Our Case Number: ABP-309770-21

Re: Proposed development of up to 15 wind turbines with a tip height of up to 175 metres and laying of approximately 26km of underground electricity cabling to facilitate the connection to the national grid, and all associated site development works
Townlands of Camagh, Carlanstown, Coole, Clonrobert, Clonsura, Doon, Monktown, Mullagh, Newcastle and other townlands, Co. Westmeath

Ár dTag | Our Ref.
TII21-112941

ABP Case ref. PA25M.309770

**Area 1.**  
N4 – L1927 Junction.  
(53.649735, -7.510959).

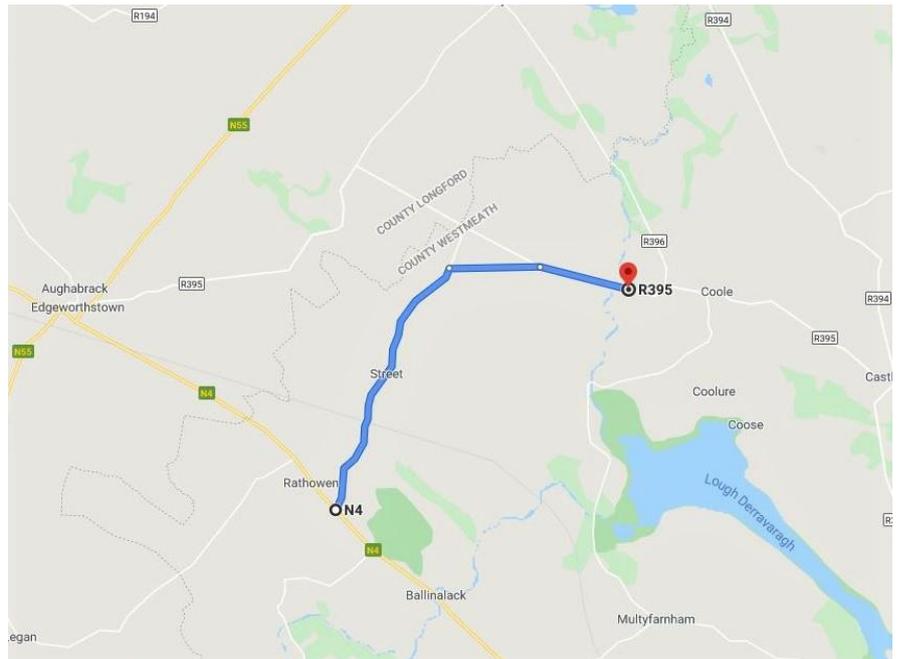
The haul route assessment included in the EIAR identifies that an area of grass verge on the southern side of the N4 at the junction of N4/L1927 will require hard surfacing. The hard surfacing is indicated as being temporary and that the verge will be reinstated to its original condition post construction.

Any proposed works to the junction of the N4/L1927 shall comply with TII Publications and shall be subject to Road Safety Audit as appropriate. Subject to the outcome of Road Safety Audit, works should ensure the ongoing safety for all road users.
